SUBJECT: Engineering Review Comment
Mountain View Electric Association Inc. (The Association)

Project Name: The Sanctuary Filing 1 at Meridian Ranch – Final Plat

Project Number: SF2220

Description: Proposed development of 343 single family lots and 5 tracts located southeast of the intersection of Rex Rd. and Rolling Hills Dr. in Township 12S, Range 64W, Section 20.

DRAWN BY: LCG DATE: JULY 2022
CHECKED BY: TAK SHEET: 3 OF 5
PCD PROJECT NO. SF-22-20

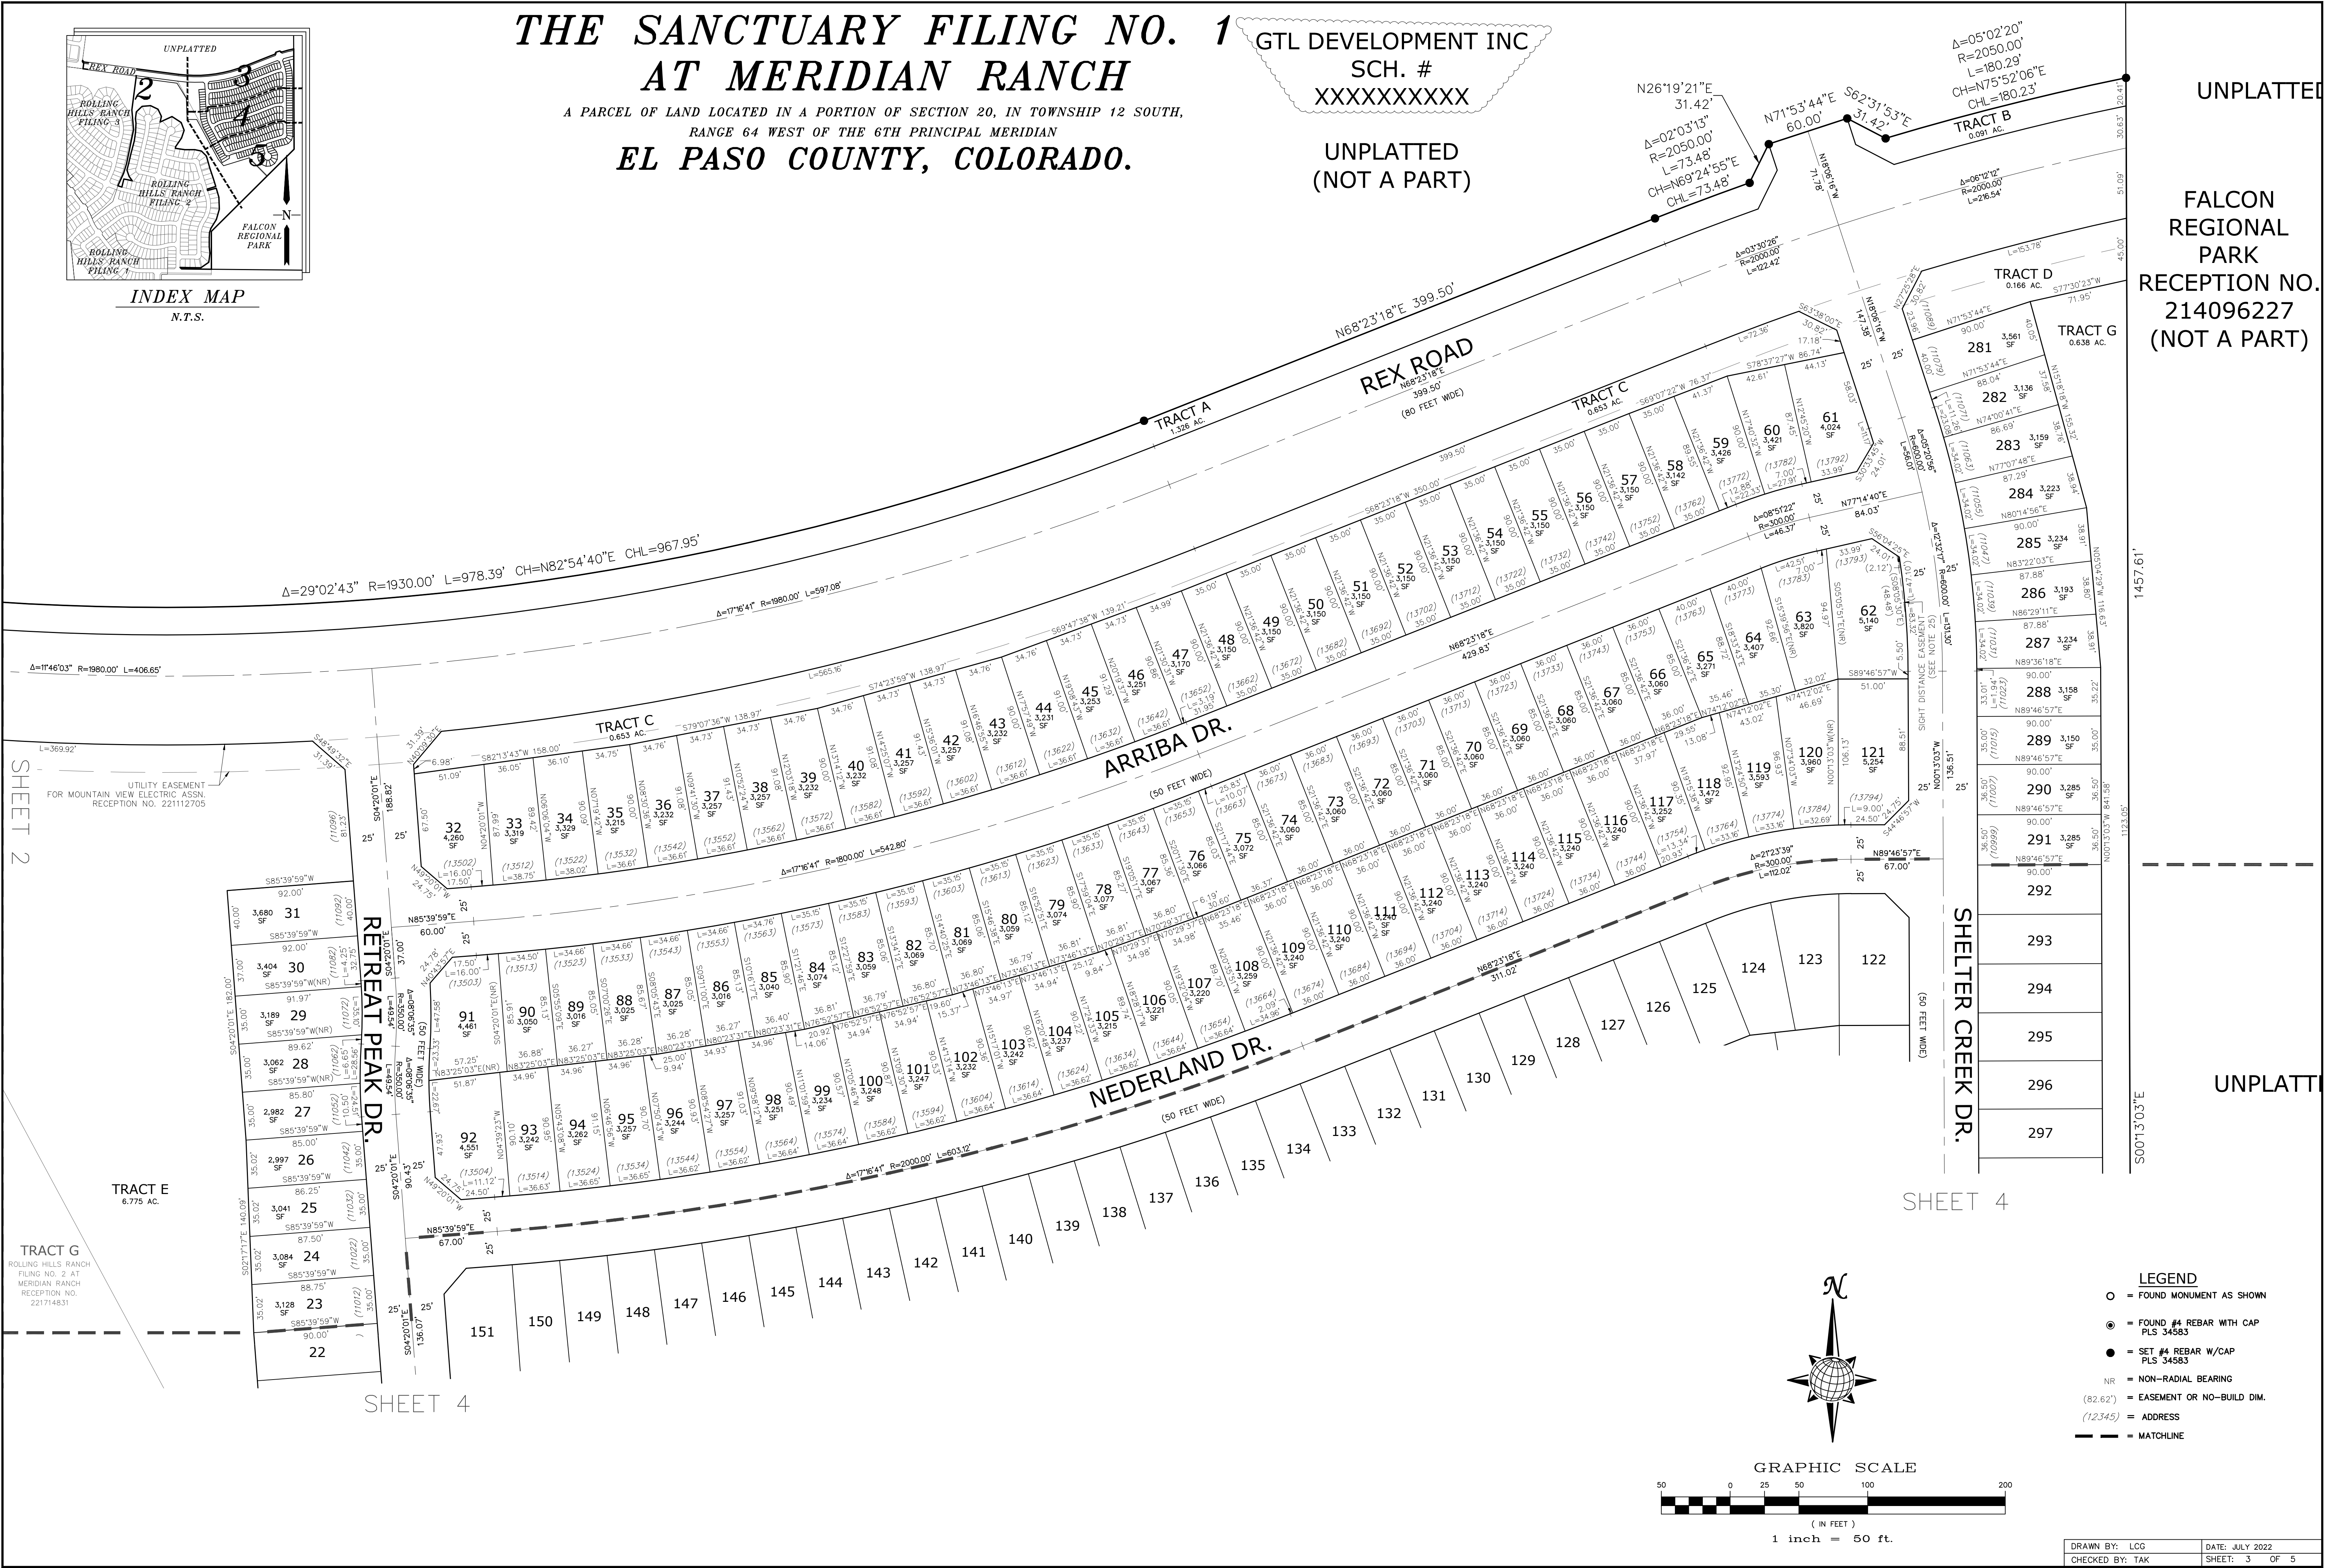
The Association requests a ten (10) foot front lot utility easement in addition to any public improvement easement, a five (5) foot side lot utility easement, and a seven (7) foot rear lot utility easement along with a twenty (20) foot exterior utility easement on the plat and all tracts include easements. The Association also requests the platting of the Association's existing facilities with easements on the plat. Additional easements may be required.
